# **City of Albuquerque**

Re: Los Prados del Norte - Unit 1, File No. D16/D8, engineer's stamp  
dated April 7, 1999.

The revised drainage report and plan dated April 7, 1999 is approved for preliminary plat and rough grading. This approval is with the understanding that Storm Drain Maintenance will maintain the 6' wide public channel. The Homeowner's Association will maintain the walkway and the adjoining landscaping area.

TITLE: **LOS PRADOS DEL NORTE**
GRADING AND DRAINAGE PLAN

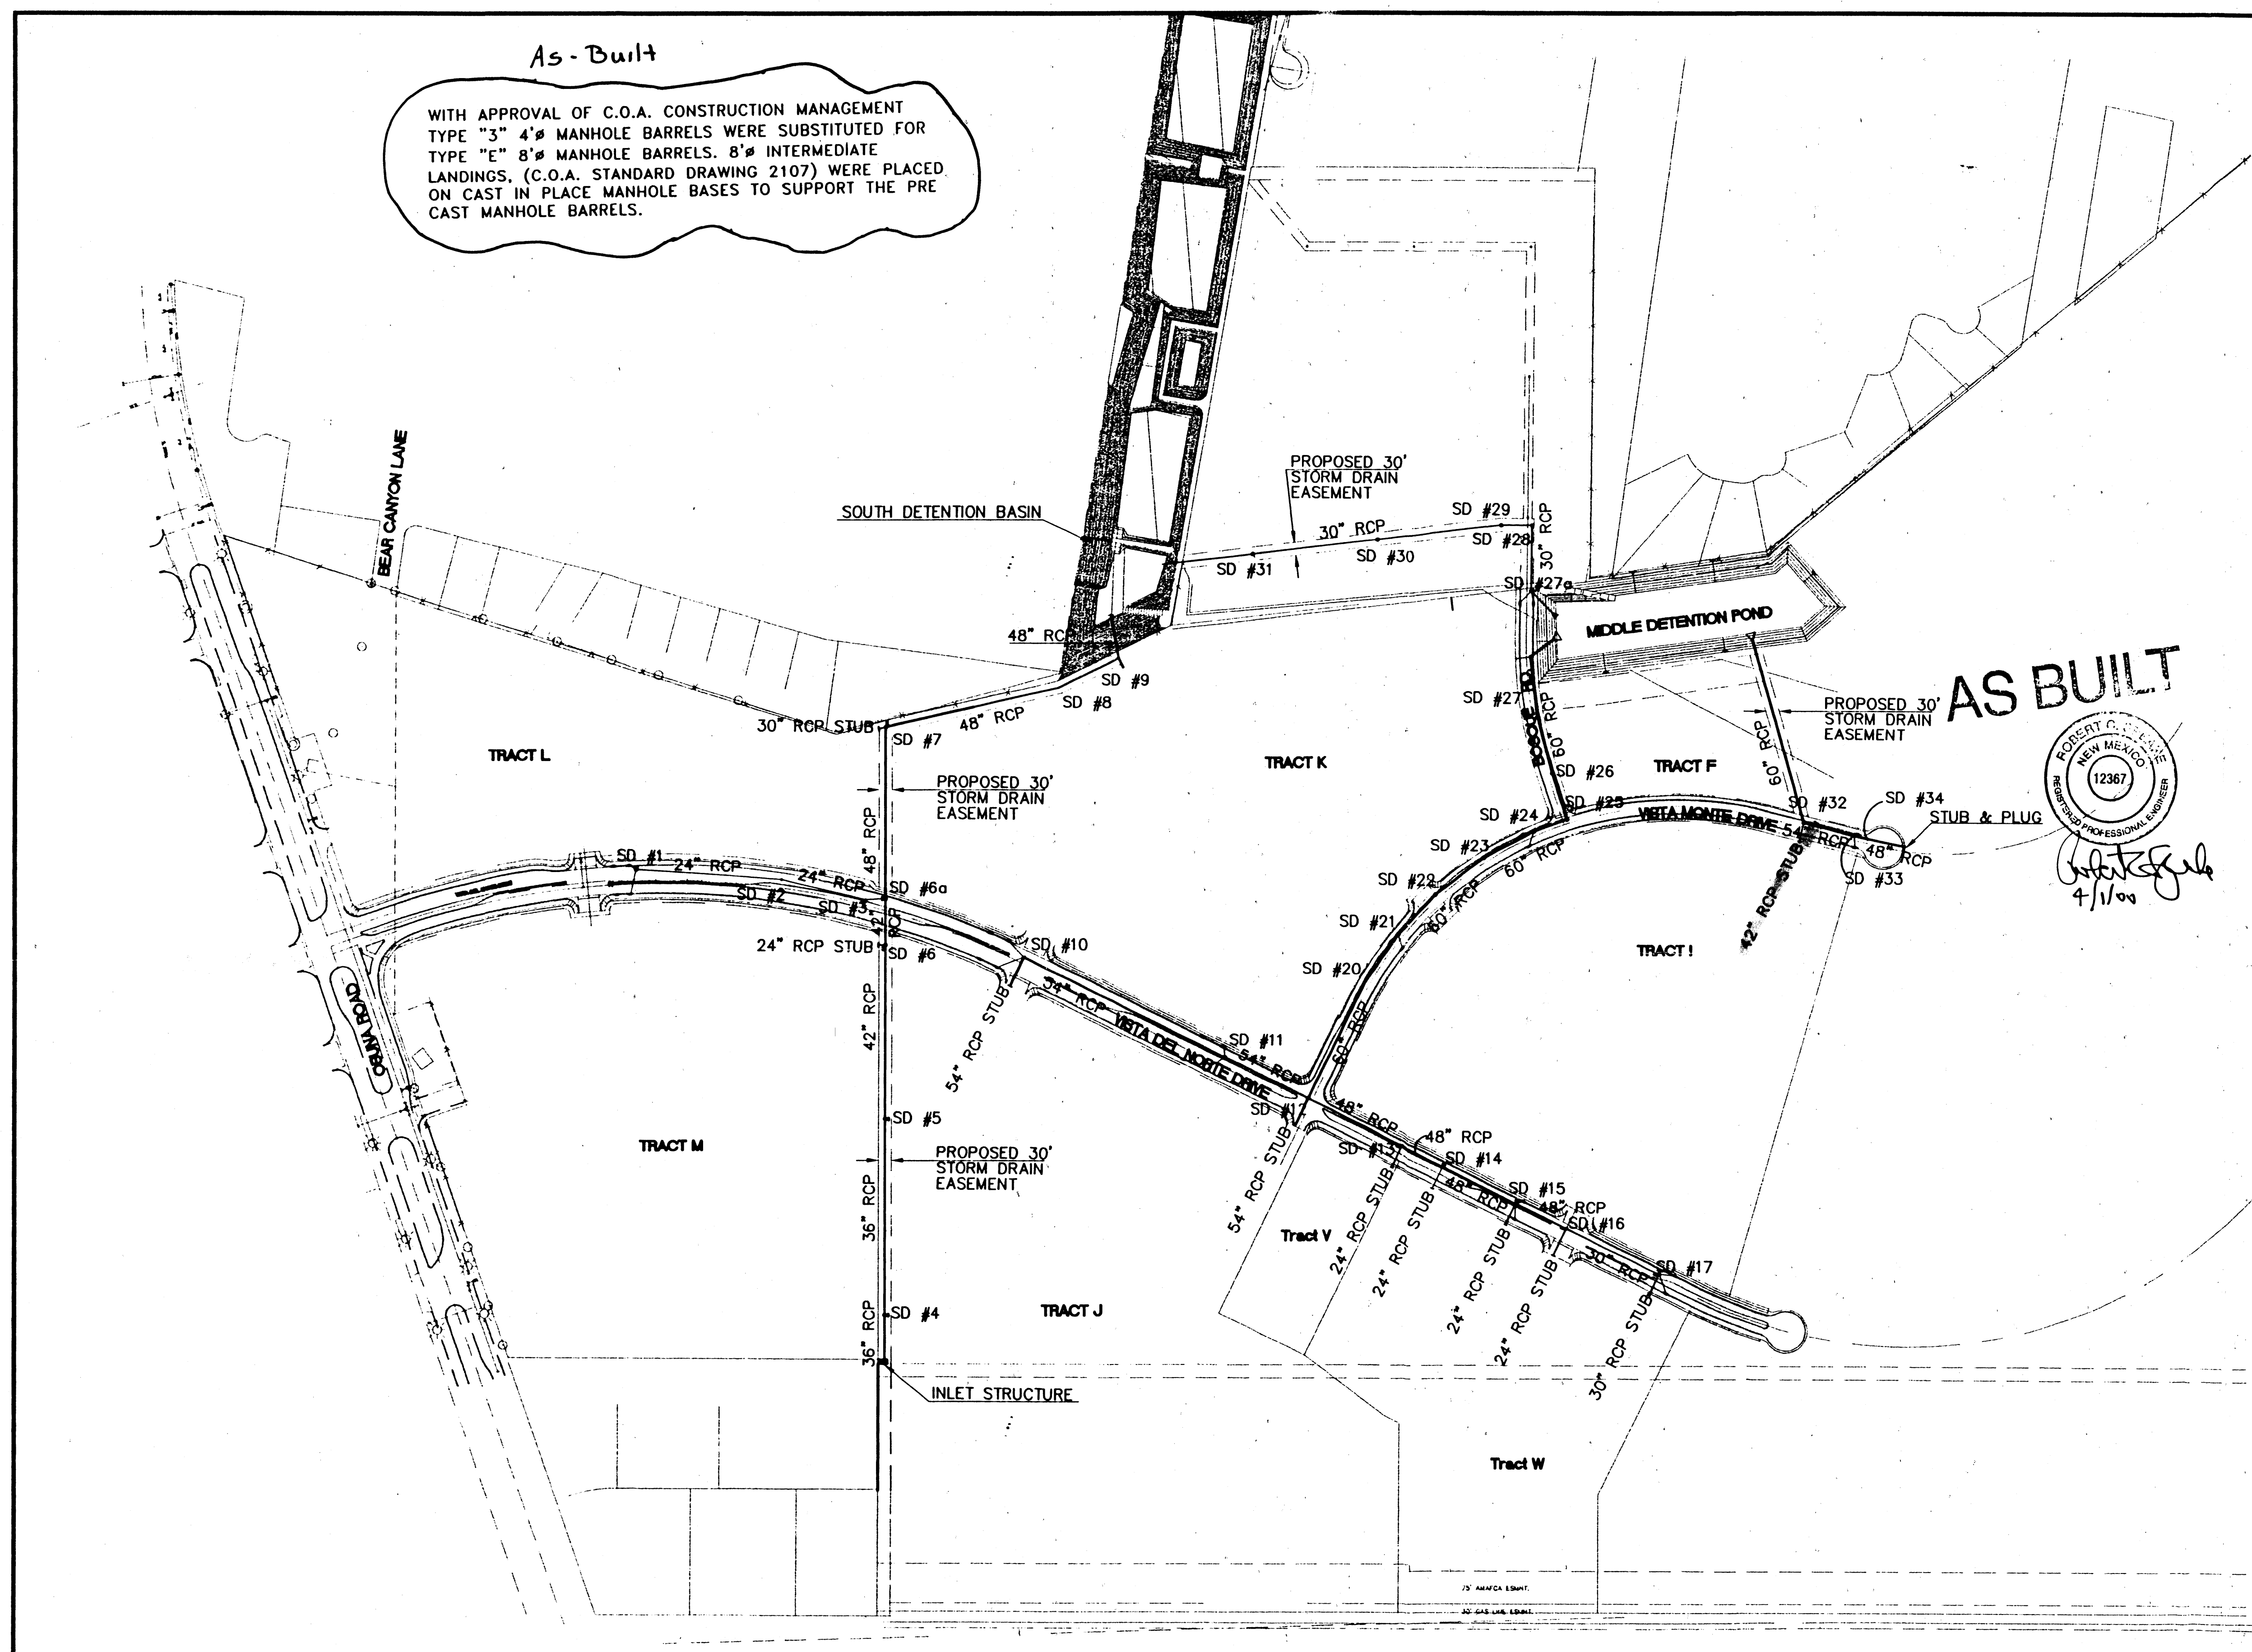
It is not clear from your letter dated April 7, 1999 what is considered the spillway that is to be maintained by the Homeowner's Association. Please provide a cross-section clearly indicating the 6' public channel, water line, private access, spillway and landscaping proposed within the 25' easement. Keep in mind that the 6' channel must be in an exclusive drainage easement, no private access will be permitted within this easement. Storm Drain Maintenance signature will be required for DRC approval.

City Project No. 5970.81	Zone Map No. D-16-Z & E-16-Z	Sheet 36a	Of 90
-----------------------------	---------------------------------	--------------	----------

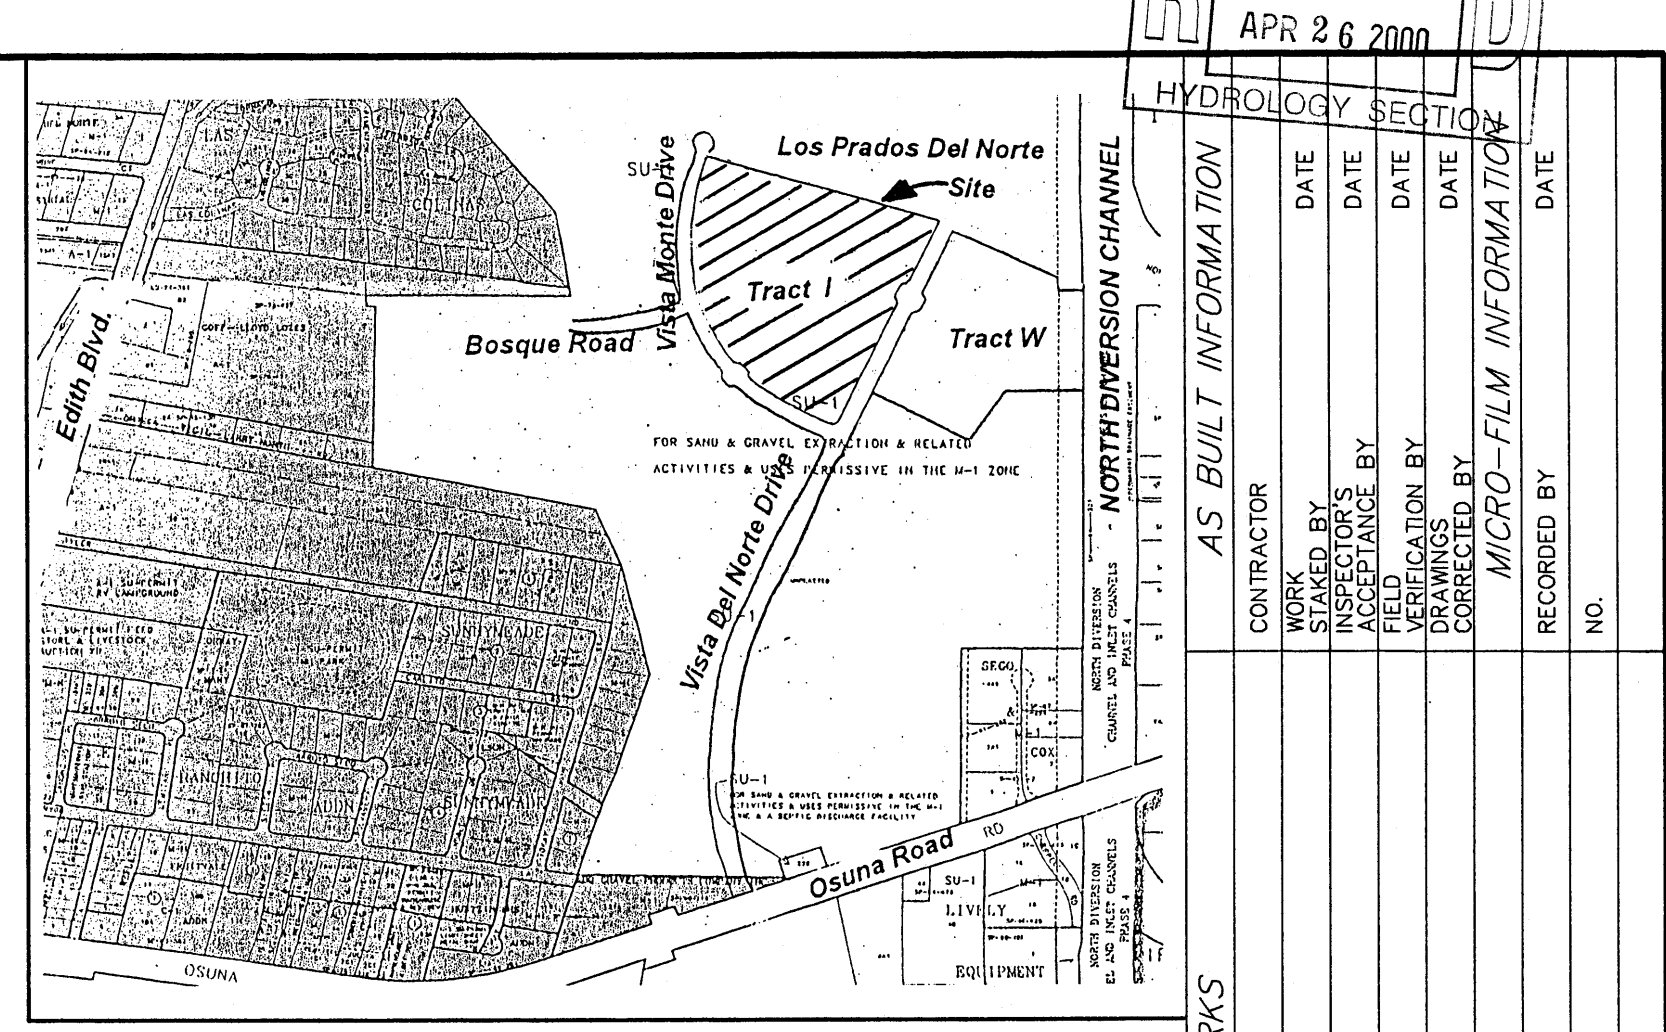
Regarding the proposed storm drains to be upsized off-site, it is understood that you will coordinate these changes with Parsons-Brinkerhoff. Prior to DRC approval the revised plan and profile sheets for the off-site storm drain must be submitted to this office to verify that the HGL is below the street grade. The required certification to release the SIA and financial guarantees will require documentation that these changes took place.
